42600 SUMMIT VIEW CT.  
PARKER, COLORADO

LANDSCAPE PLAN  
 SHEET 1 OF 1

# Landscape\_v1-redline.pdf Markup Summary

EL PASO COUNTY CODE	REQUIRED	PROVIDED
PARKING SPACES	XX	17
LANDSCAPING	XX	XX

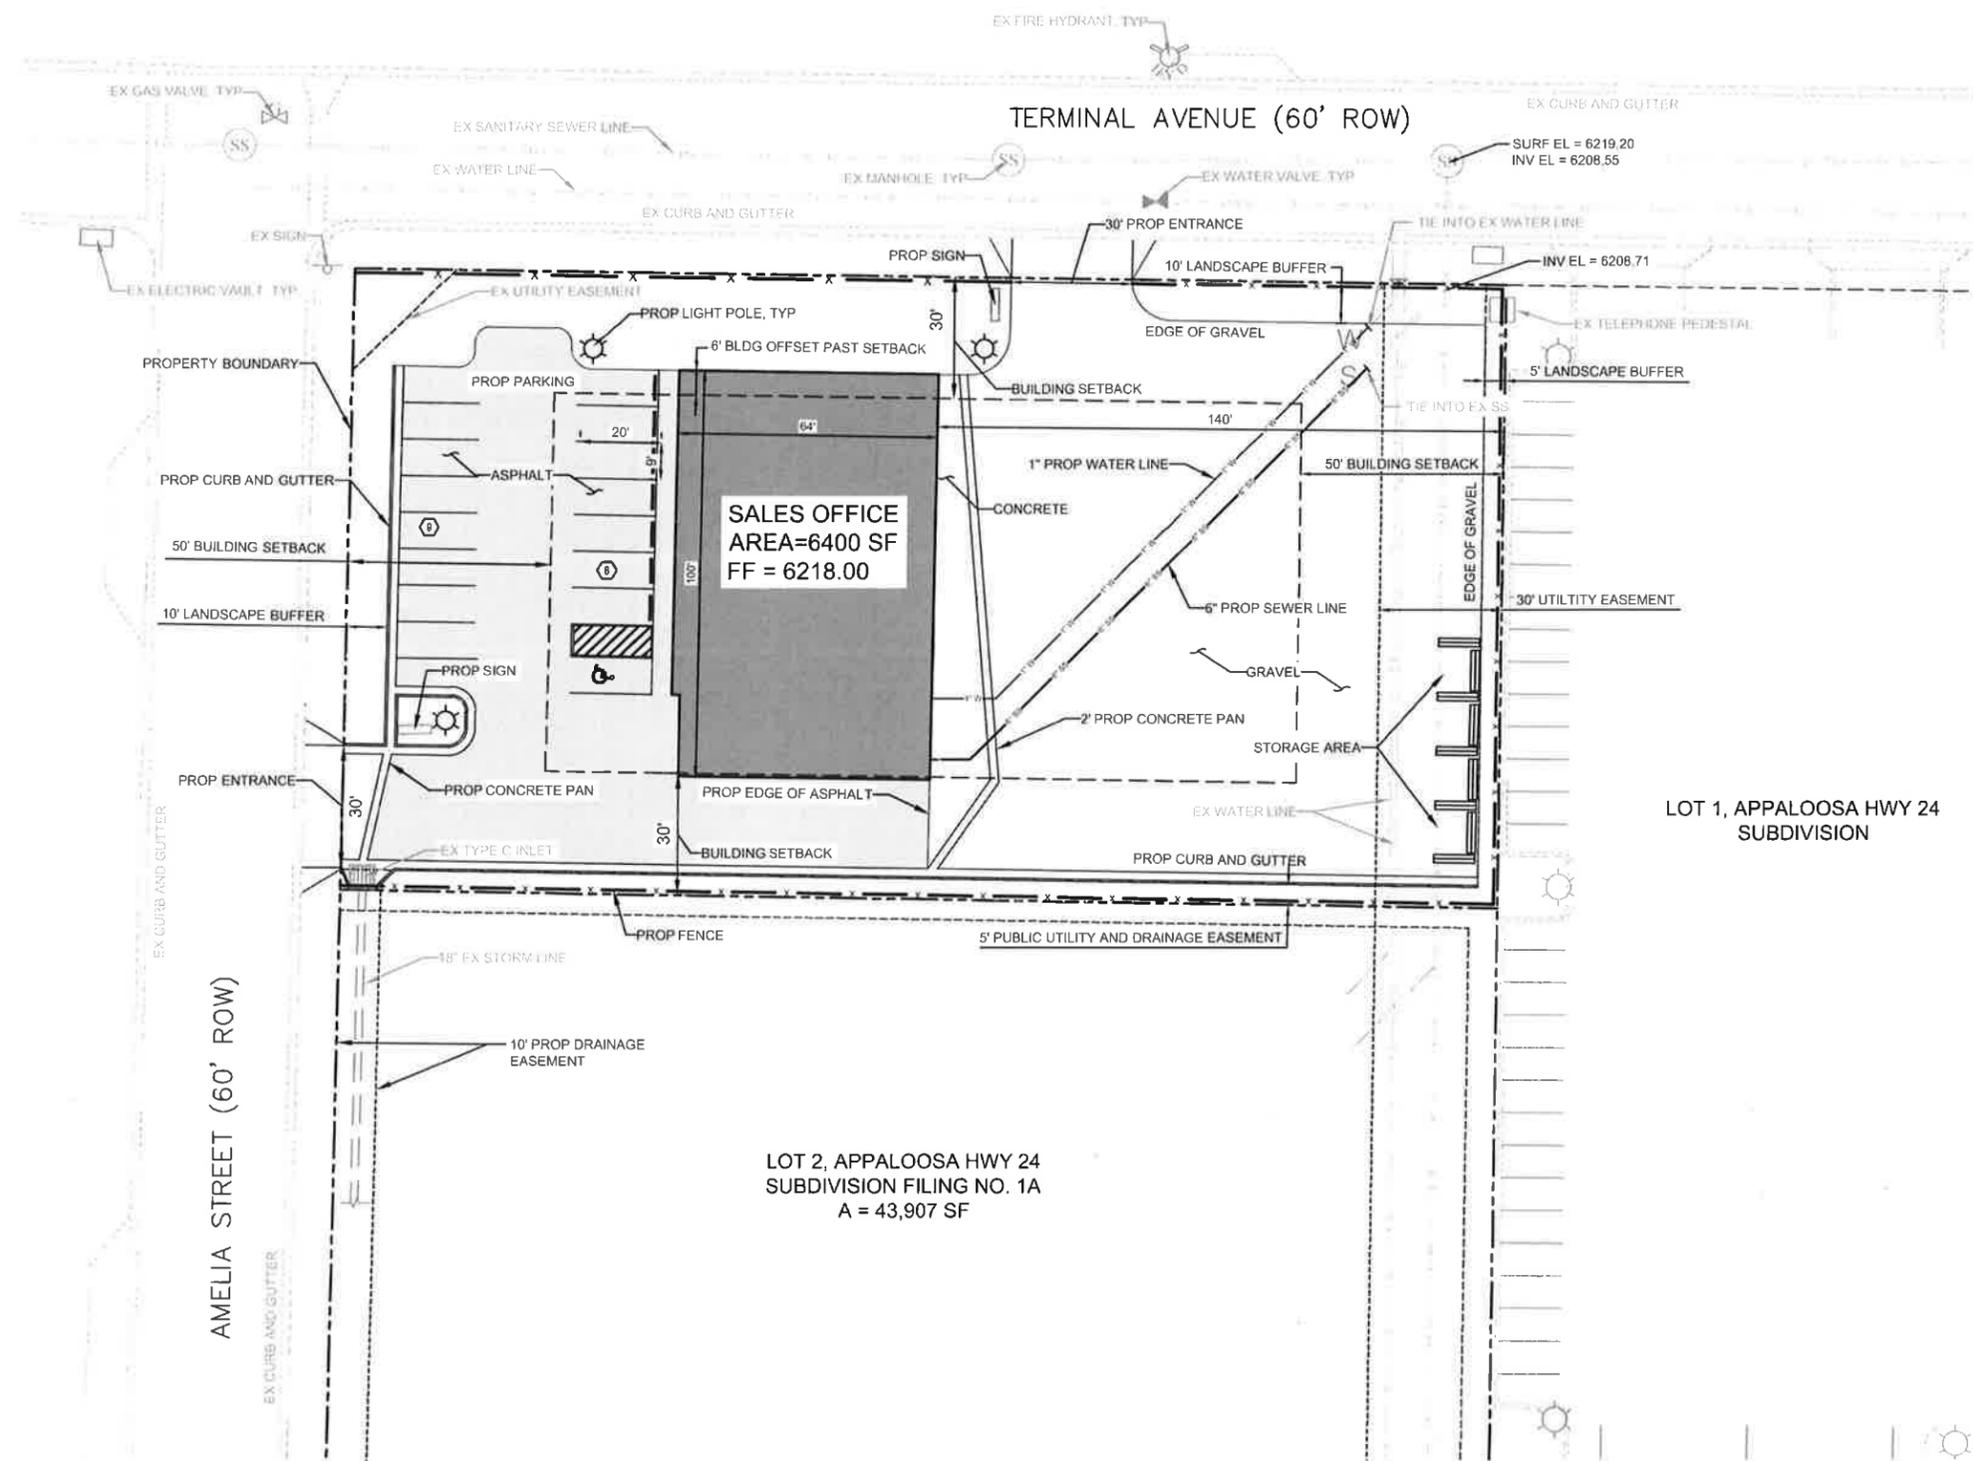
Show how many trees are required as well as provided. Show which type of landscaping they are for, for example:  
 Roadway Landscaping: Required/Provided  
 Internal Landscaping: Required/provided - percentage and trees  
 Etc.

Show distance of frontage.

5 percent of lot area should be internal landscaping, 75% of that should be live ground cover, an alternative landscape plan may be requested, approval of that would be at the Director's discretion.

See chapter 6 of Land Development Code for landscaping requirements.
